Application No: BN/62/21/PL
Site Address: The Croft Surgery Barnham Road Eastergate PO20 3RP
Description of works: Medical centre with pharmacy retail unit & other ancillary uses together with access onto Barnham Road, associated car parking and other hard and soft landscaping works. This site is in CIL zone 2 (Zero Rated) as other development.

Thank you for your internet representation made on 19th June 2021 which has been recorded as no objection with the comments as follows:

PROPOSED SITE PLAN

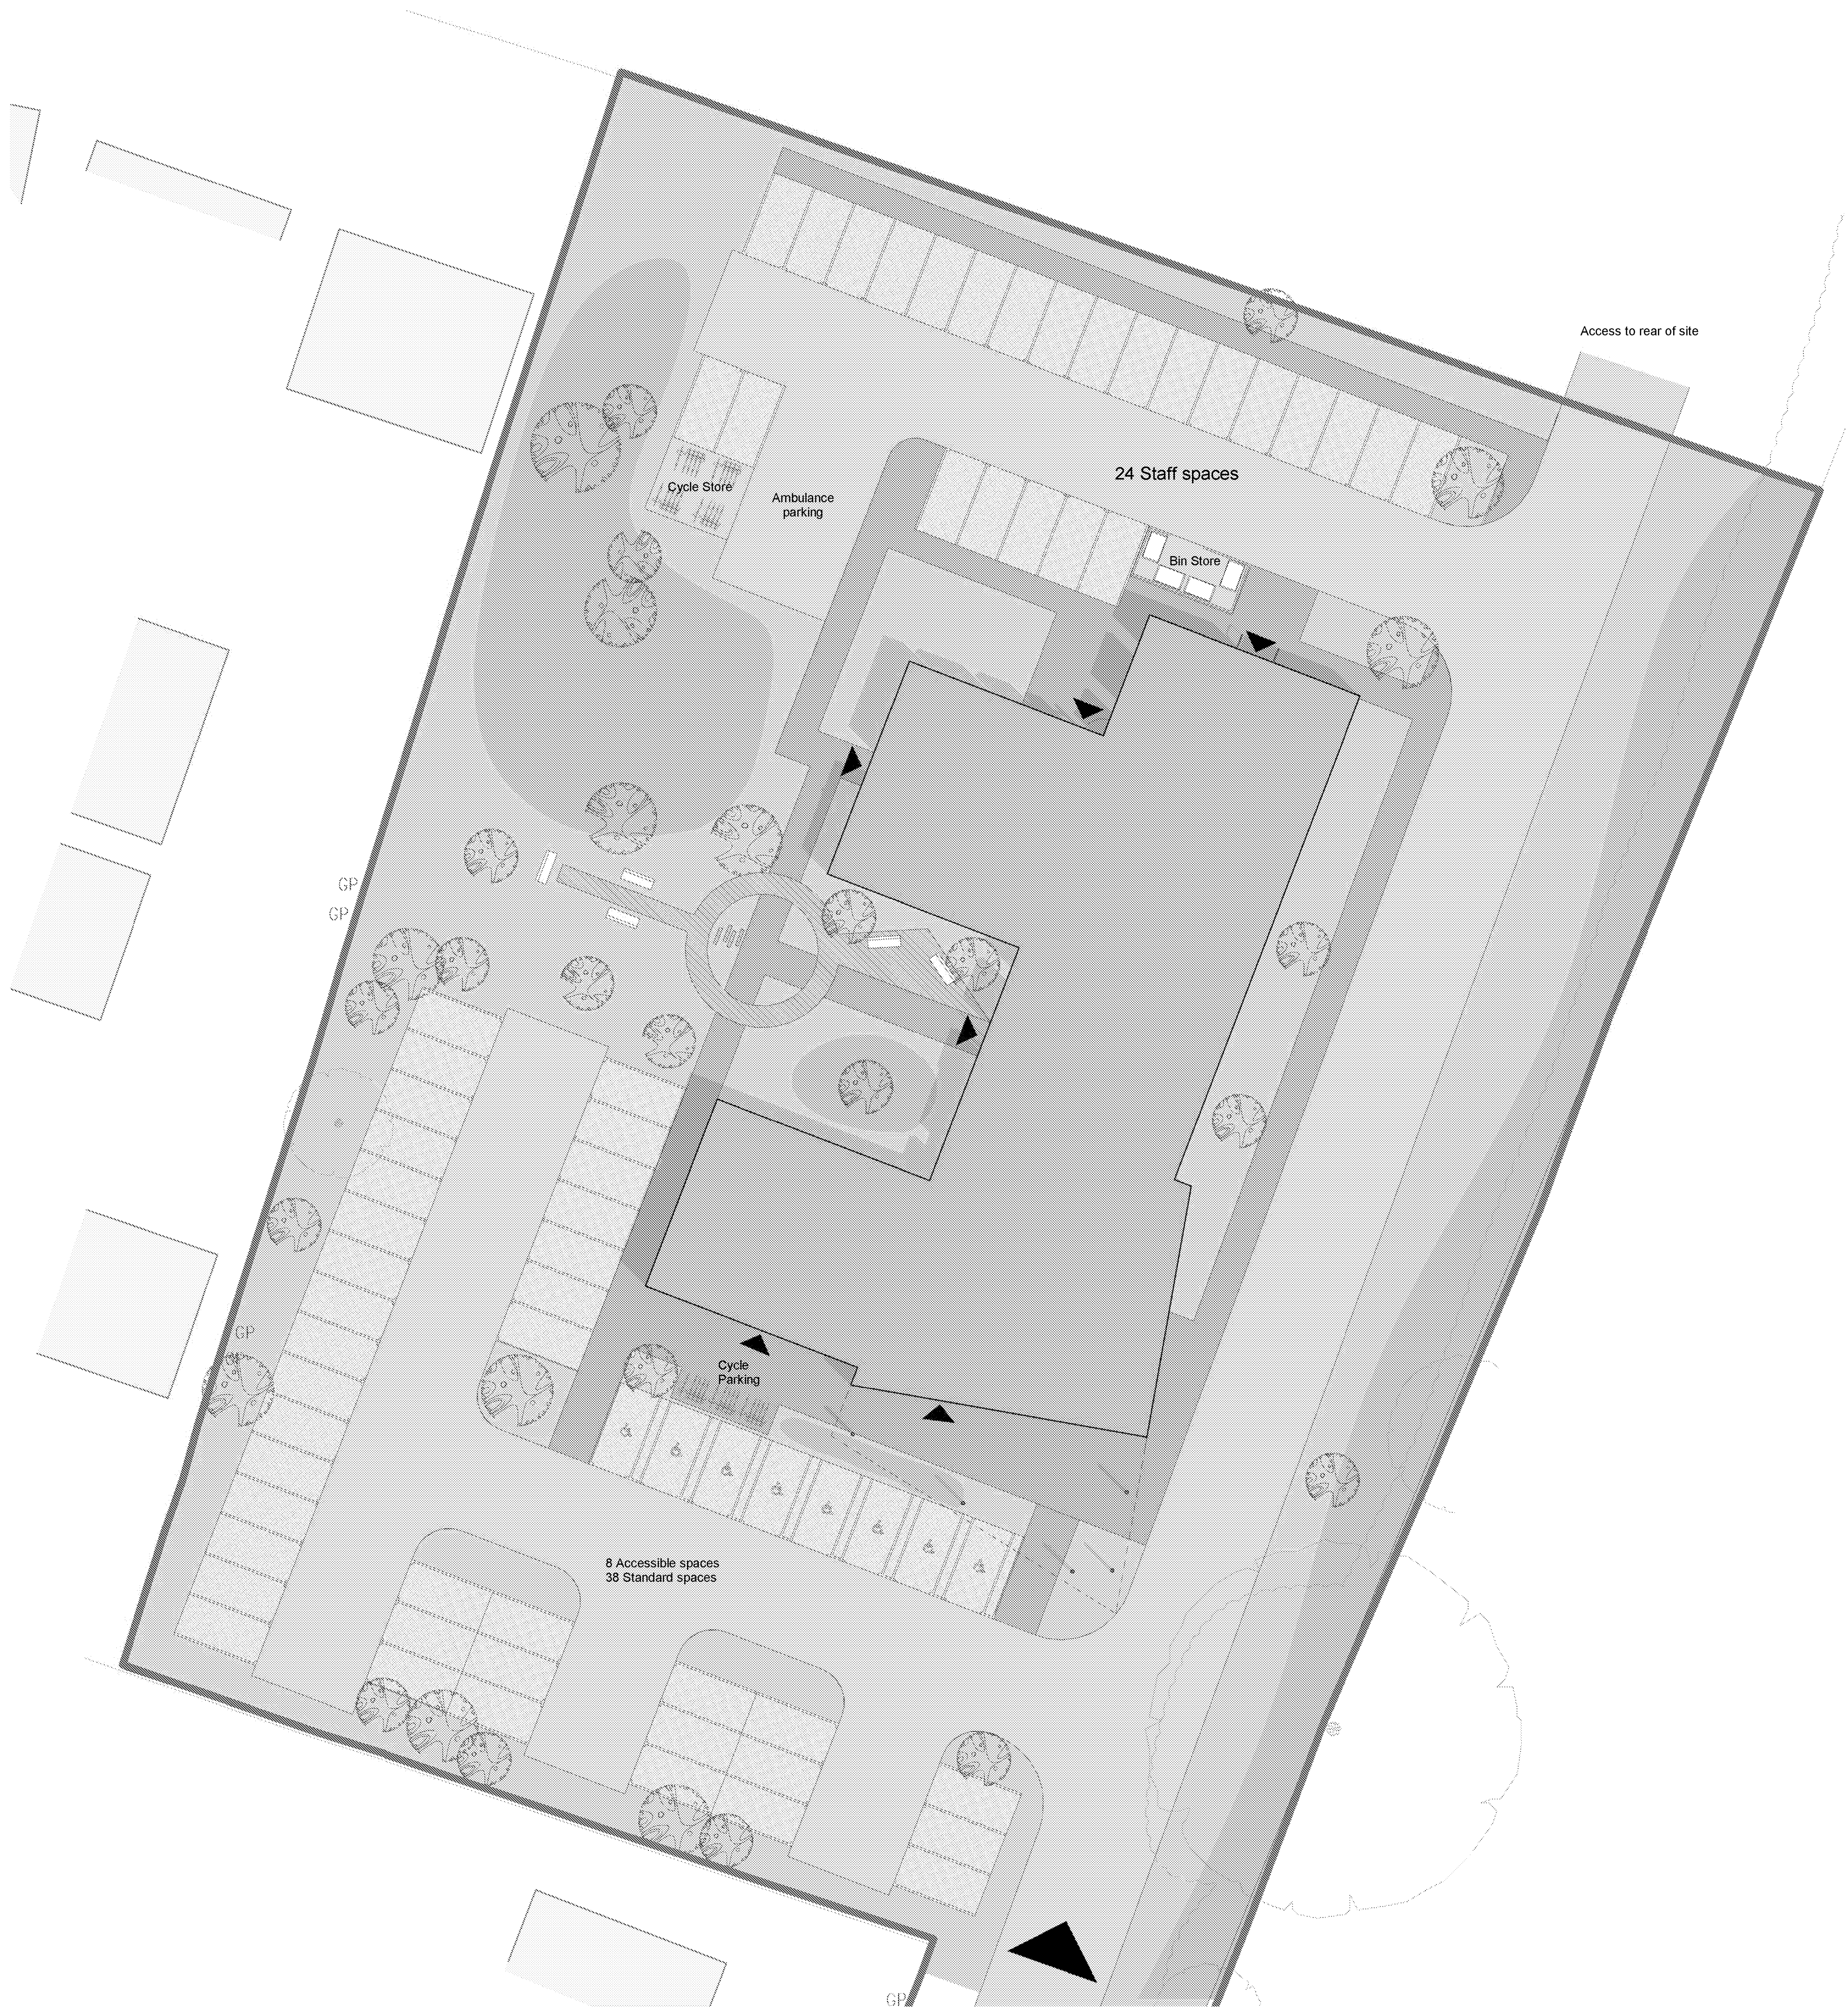
Where is the lift for disabled access to the first floor? This will be on the Western side of the new A29 and make access very difficult and prohibitive to residents of Barnham. Where are the disabled parking spaces? It will only suit the residents of the new Barnham about to be built but not old Barnham. Do we now need to have a separate facility for old Barnham? They do not have enough staff for the current building and cannot get them. Where are they going to find the staff for this bigger facility?
